**SSD\_7054: LEES 1 BUILDING AND SSD\_7055: F23 ADMINISTRATION BUILDING**  
**UNIVERSITY OF SYDNEY RESPONSE TO SUBMISSIONS**

The University of Sydney has reviewed all submissions received during the statutory public exhibition period of State Significant Application *SSD 7054 – F07 LEES 1 Building* and the *SSD 7055 – F23 Administrative Building*, both located on the southern edge of the University's Camperdown campus fronting City Road.

1:00 PM - WINTER SOLSTICE

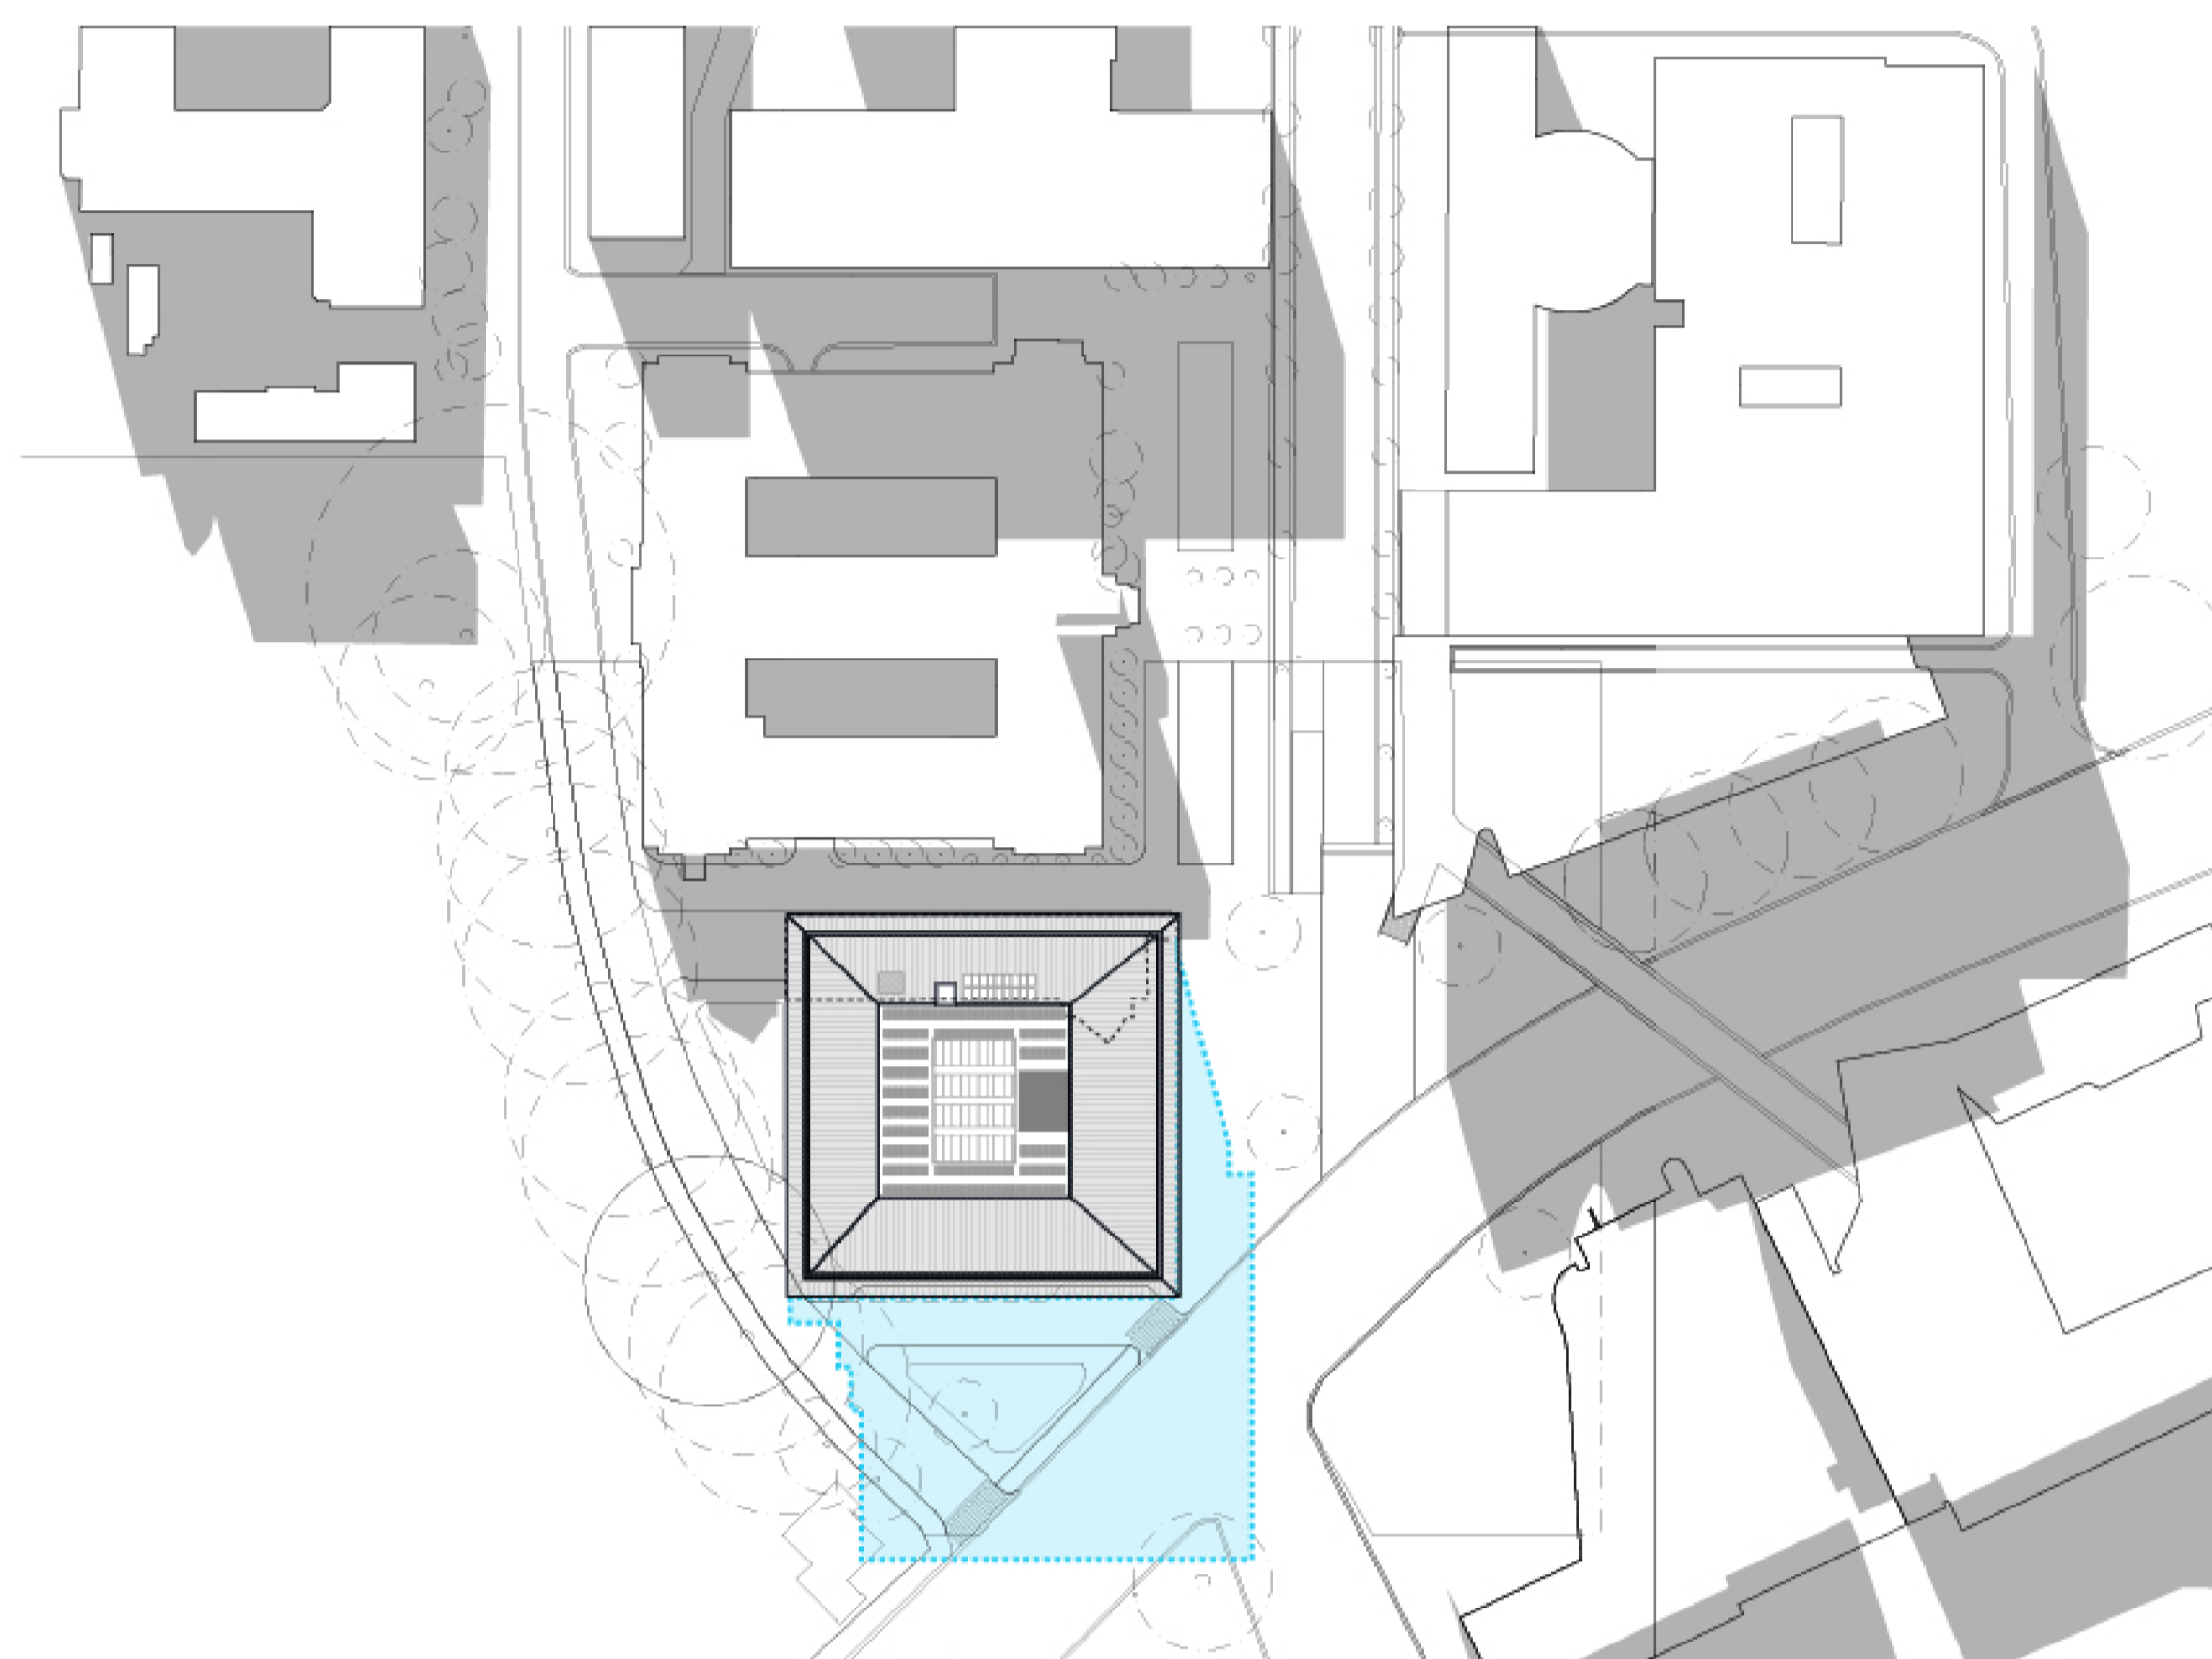
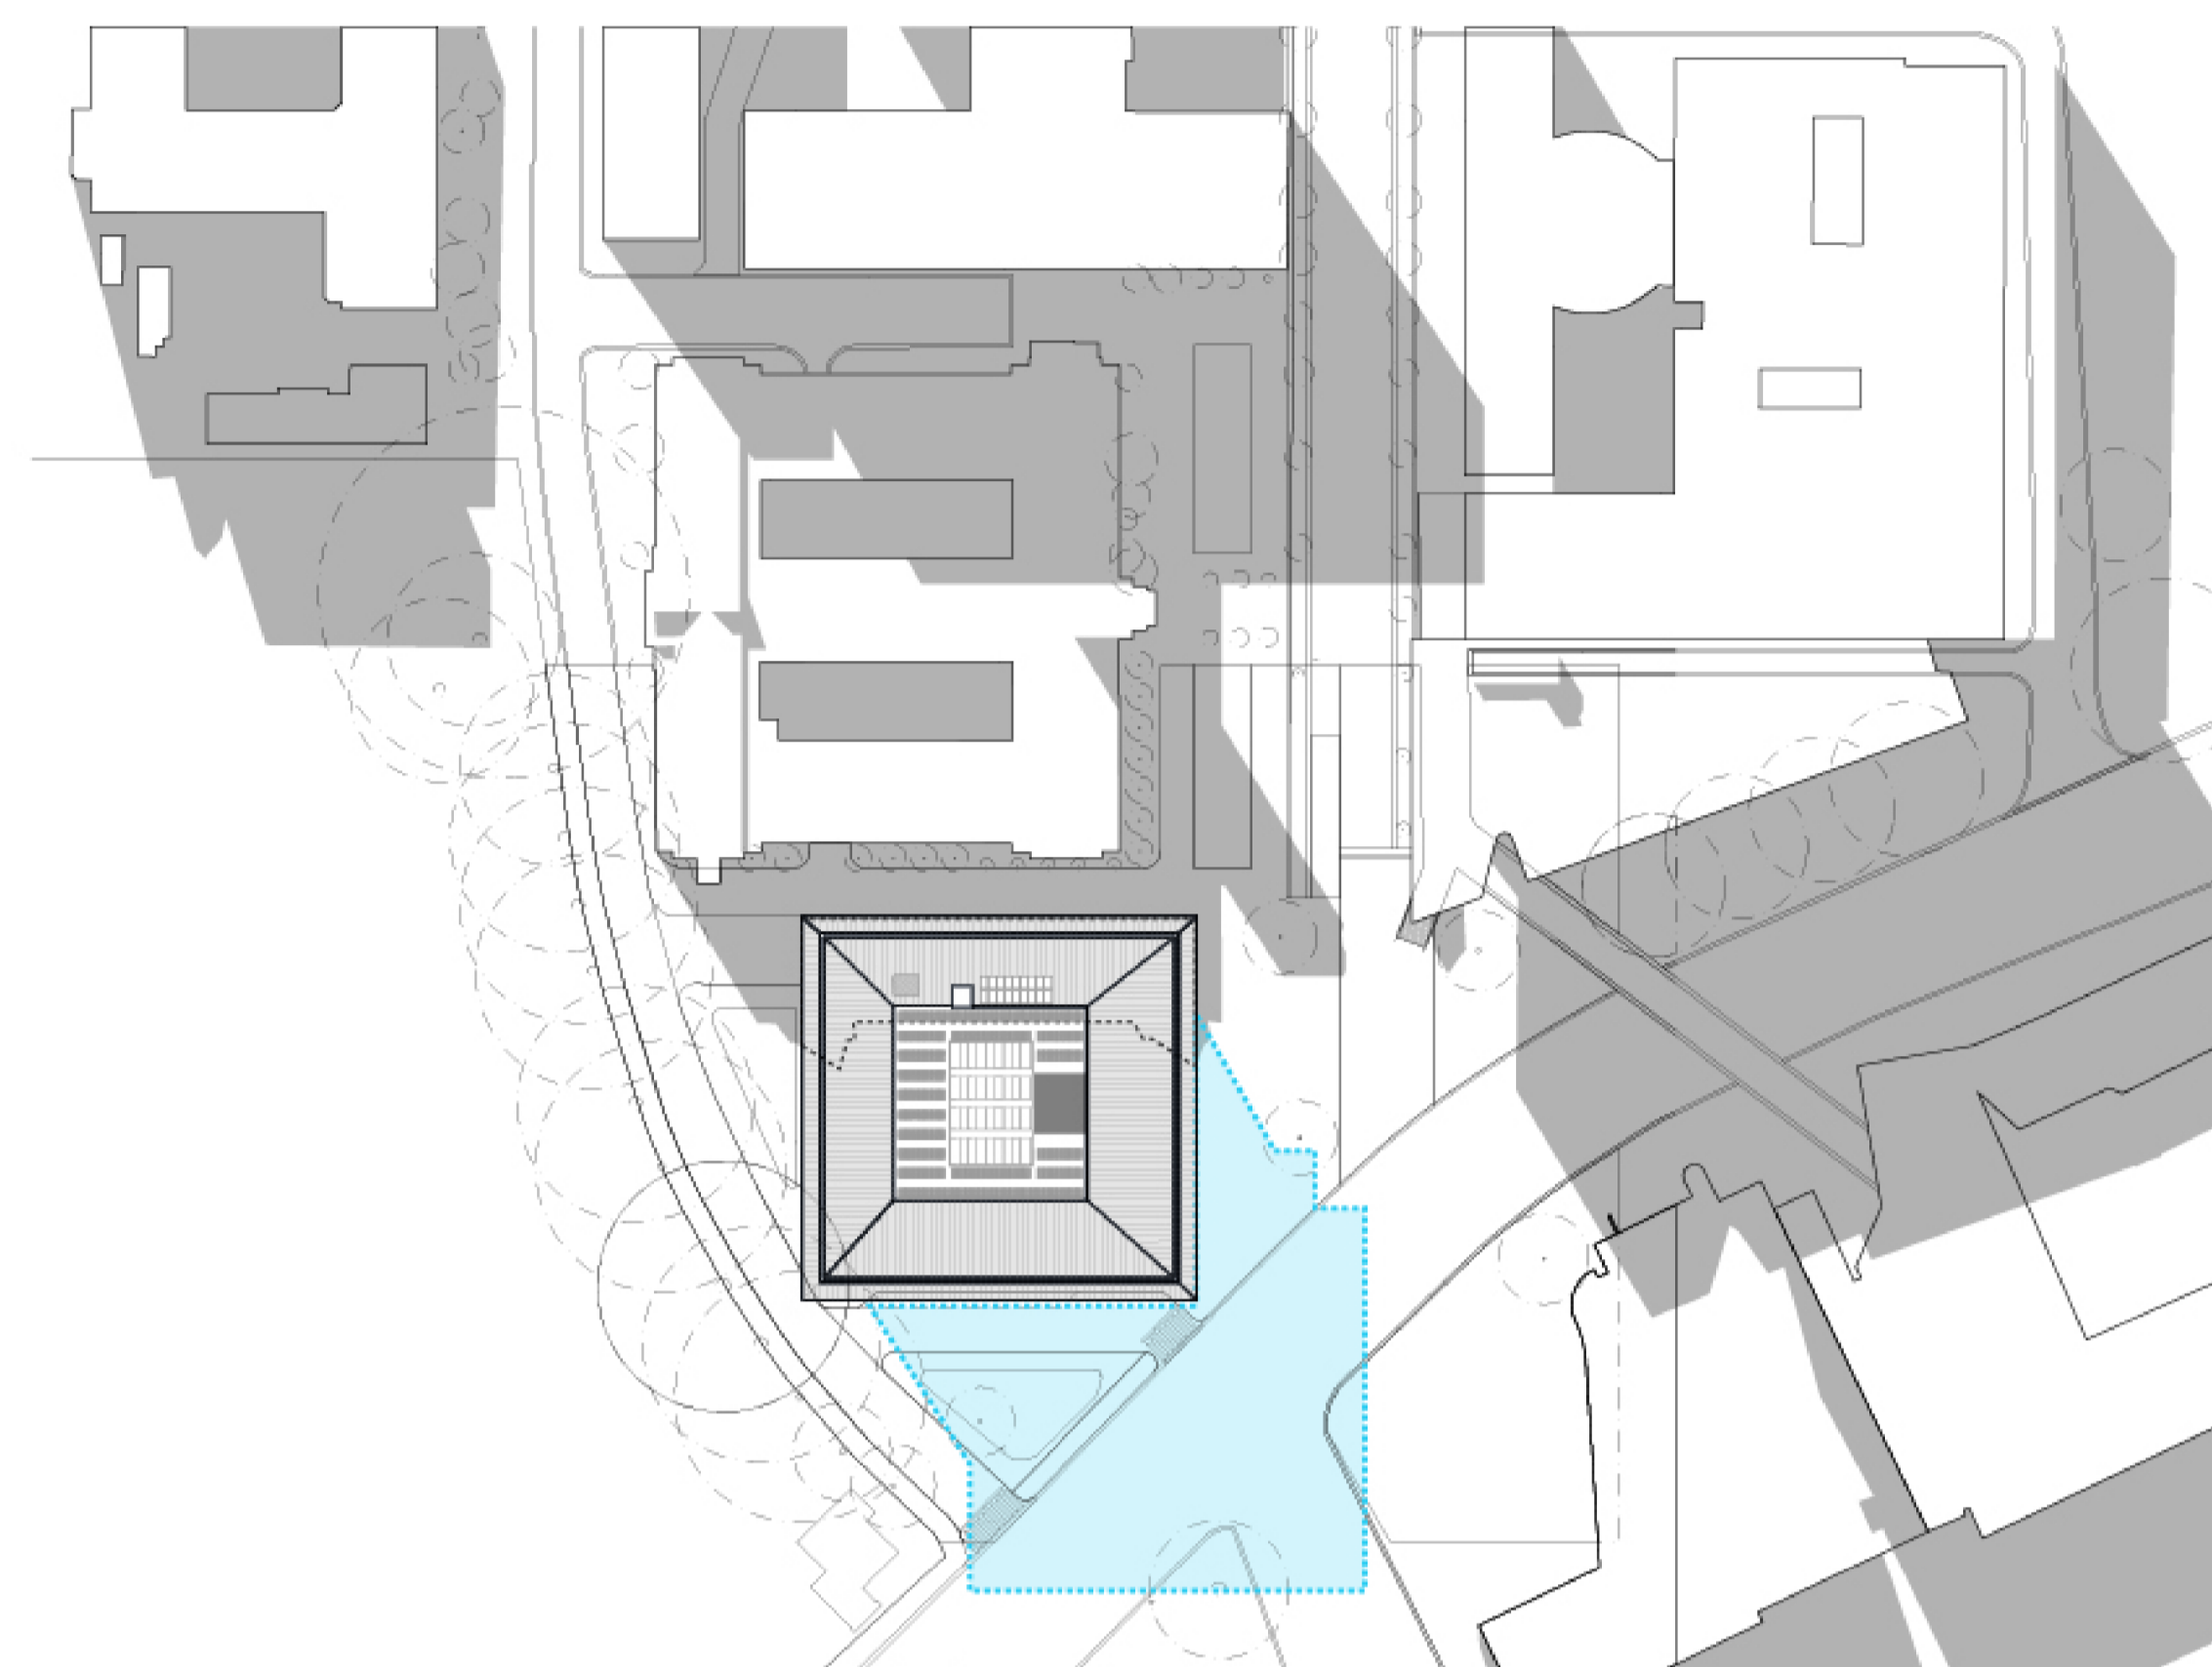
<p><b>8. Overshadowing</b></p> <p>Detailed diagrams are required to differentiate the existing shadow from that of the shadows cast by the proposal.</p>	<p>Amended shadow diagrams have been updated and included in <b>Appendix 01.03</b>.</p>
<p><b>9. Flooding</b></p> <p>The site is subject to flooding. The recommended finished floor levels specified in the Flood Report must be applied to the proposed development and thus comply with the City of Sydney Interim Floodplain Management Policy.</p> <p>As there are a number of stormwater upgrades proposed, a stormwater quality assessment should be provided in accordance with the Sydney DCP 2012 requirements.</p>	<p>Flood levels have been provided as per the civil stormwater report dated 16 March 2016.</p> <p>The finished floor levels are required to be 500mm above the levels as specified i.e. FFL 35.70 (proposed FFL 35.75) at entrances’ to the western side, and FFL31.80 (proposed FFL 32.10) on the eastern (Barff Rd) side, thus complies with the City of Sydney’s Interim Floodplain Management Policy. Refer to the attached drawings indicating the proposed FFLs.</p> <p>With respect to the water quantity, since the issue of the report, the stormwater strategy has changed in that we are now discharging to the Council/ Sydney Water system in City Road rather than the University of Sydney’s downstream network. The University is required to comply with parameters that Sydney Water has sent is in terms of OSD volume (37m<sup>3</sup>).</p>

F23 ADMIN BUILDING - UNIVERSITY OF SYDNEY

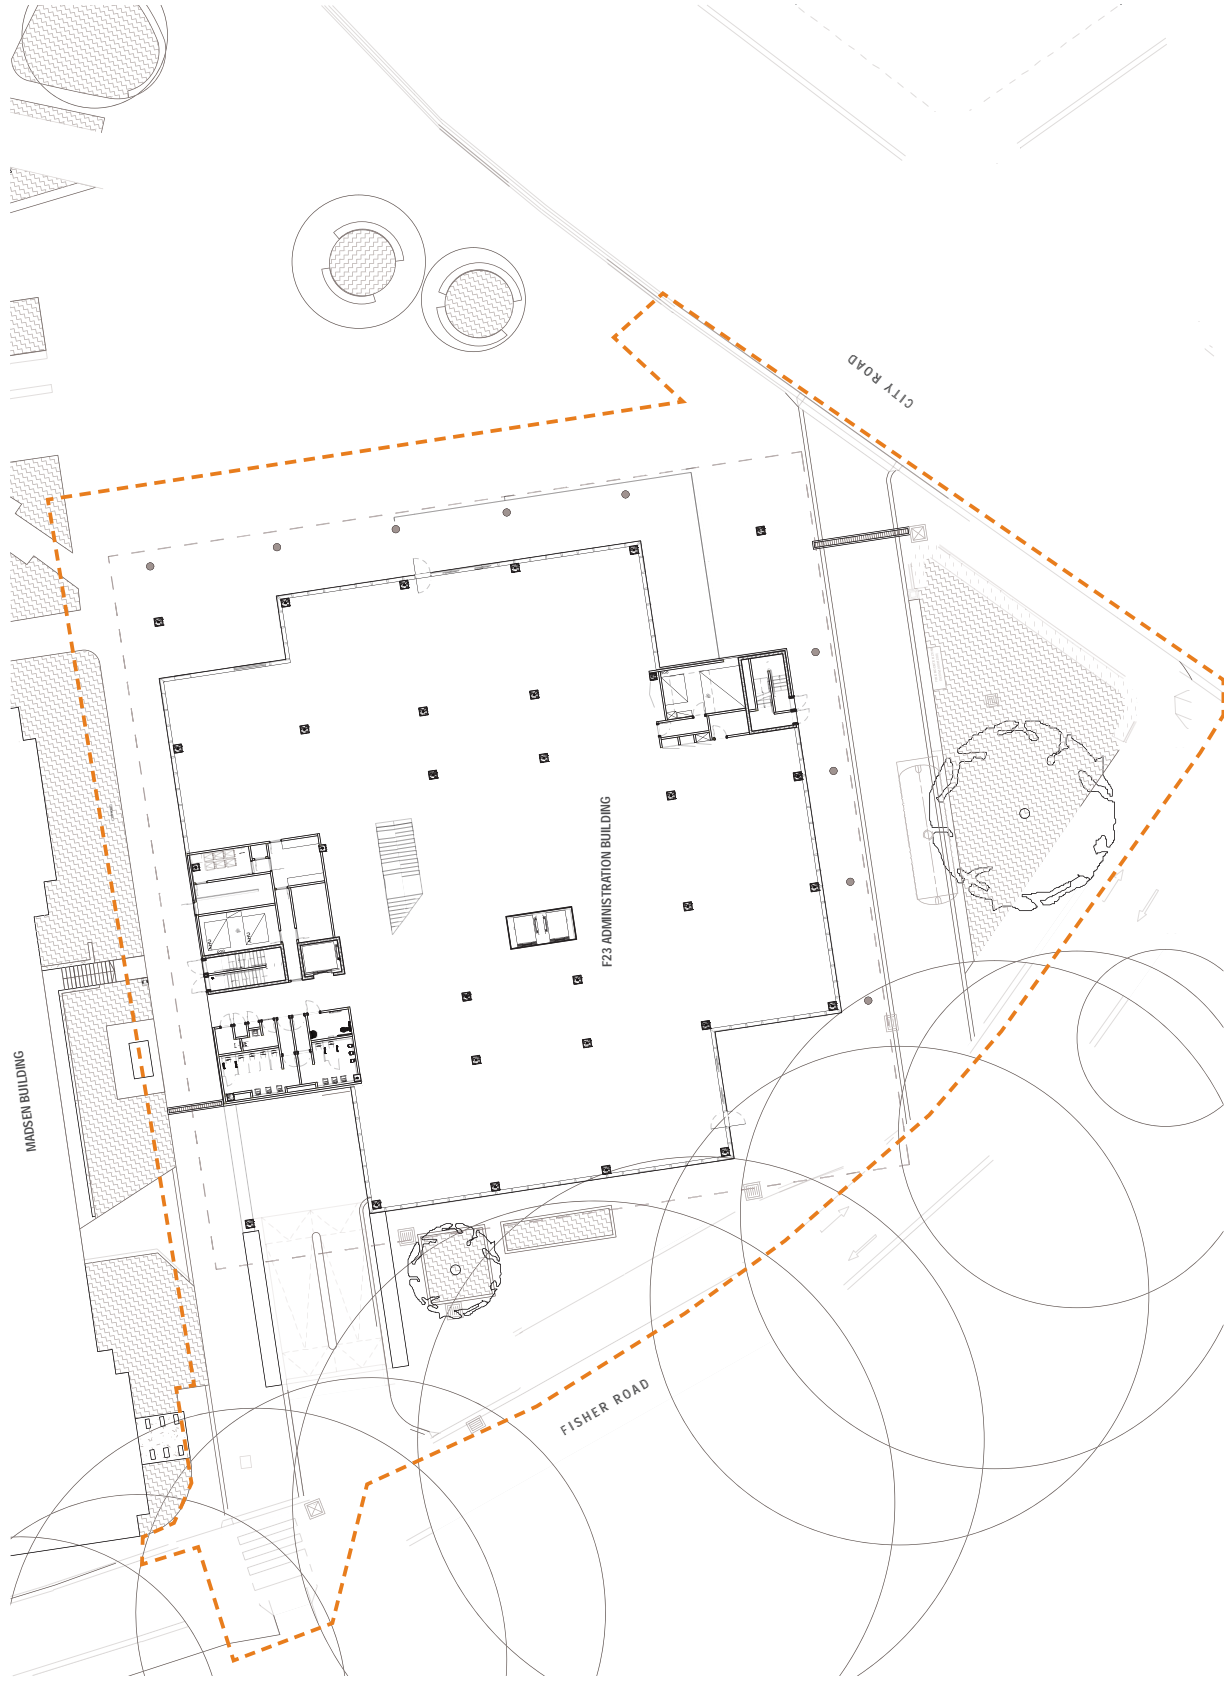
3. The submitted Arborist report recommends replacement planting is to compensate for the proposed removal of 17 trees from the site, however, only two new trees are proposed. Justification is to be provided for the lack of proposed compensatory planting.	An updated Landscape Plan (F23-A-DA-0204 GA Landscape Plan) in <b>Appendix 2.02 - F23 Amended SSD Plans</b> , includes the provision of additional replacement trees.  In addition, Tree 435 is being transplanted from the front of Eastern Avenue to the front of the proposed F23 building, adjacent to City Road.
